KVFR Prevention Conditional Use Permit Comments

Project: Brick House Nursery Event Center

Permit#: CU-22-00004

Date: 12/06/2022

**SITE PLAN 11x17
EVENT USE**

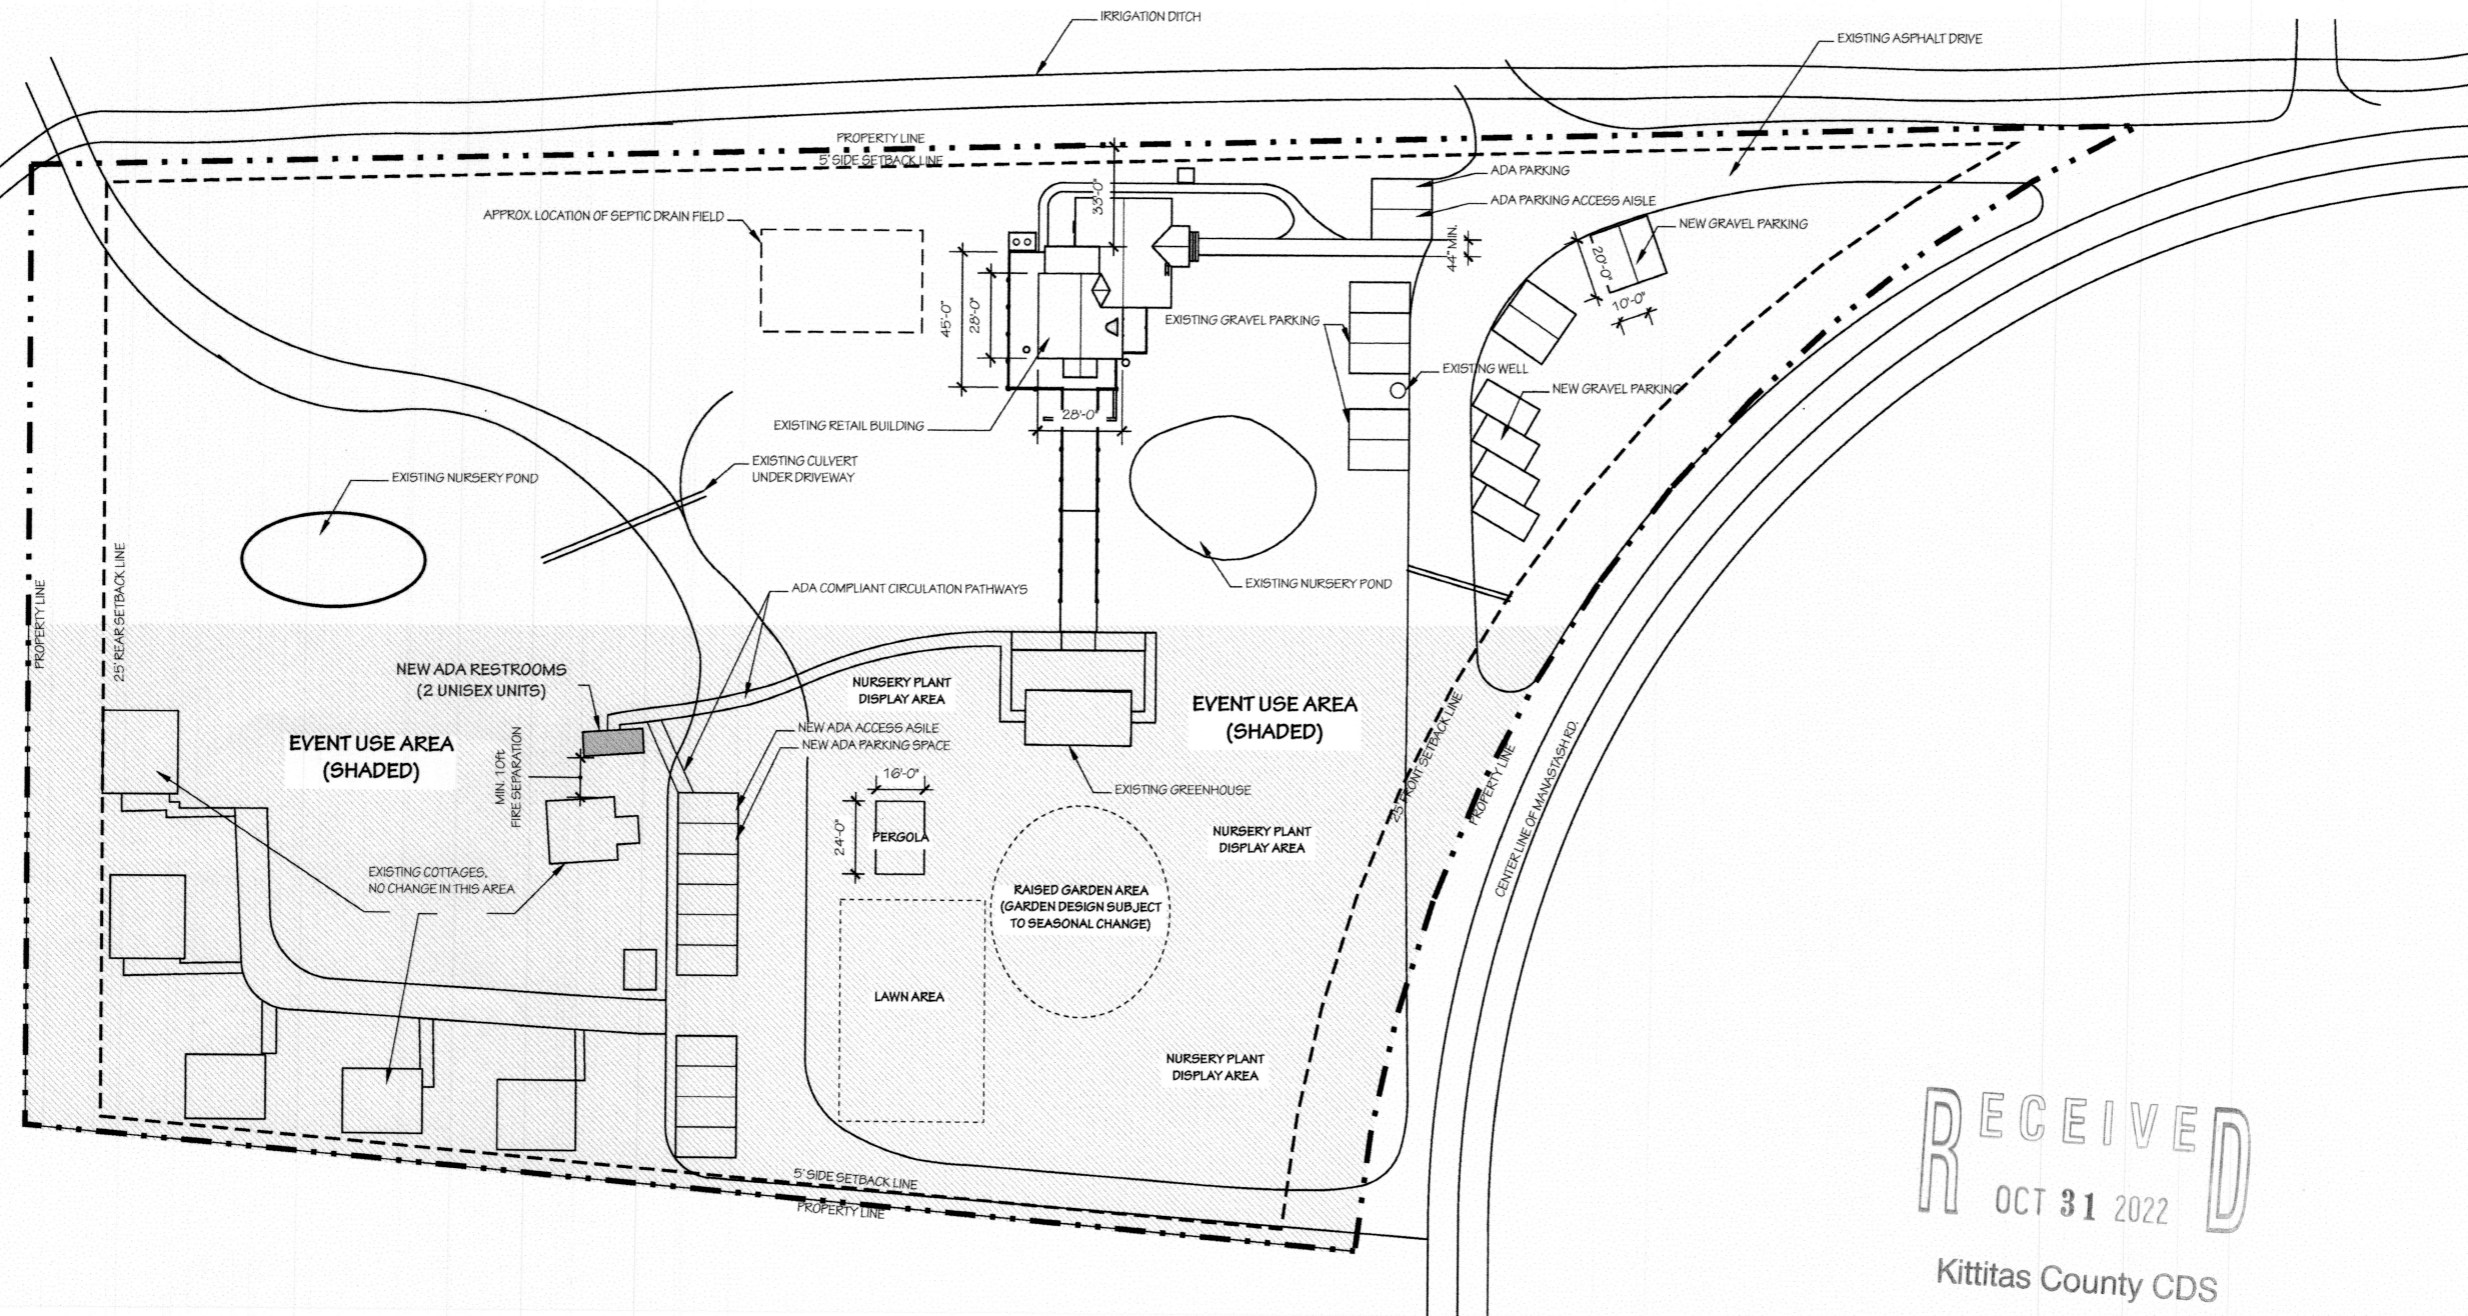
- Fire apparatus access roads exceeding 150' shall be provided with a temporary or permanent turnaround meeting the requirement 2018 IFC Appendix D. This does not appear to be met for the associated proposed area or use.
- Sufficient parking, based on occupancy and to not interfere with fire lanes and building access.
- The IFC Appendix D requires the road be a minimum of 20' wide and capable of supporting an imposed load of at least 75,000 lbs.
- Buildings would be required to meet current IBC, IFC, WUI, requirements due to the change in use for the commercial occupancy. This may include fire sprinklers, fire alarm, exiting, emergency lighting, etc. This cannot be determined without more specific information.
- Our standard turning radius is a minimum of 23' inside and 45' outside.
- Water supply meeting Kittitas County requirements.

- b. The proposed restroom building will need to be made accessible.
- c. Accessible parking and route to Accessible space(s) provided with hard surface such as asphalt or concrete. The parking symbol and signage of Accessibility is required. Accessible parking spaces shall be located on the shortest accessible route of travel from adjacent parking to an accessible building/ pedestrian entrance per WAC 51-50-1106. Wherever practical, the accessible route shall not cross lanes of vehicular traffic. Where crossing traffic lanes as necessary, the route shall be designated and marked as a crosswalk.

- d. Verify there is no more than 1:20 slope for the Accessible path from Accessible Parking to the building(s) and all facilities entrances and amenities. Please show path and state the maximum allowed slope on the drawings.
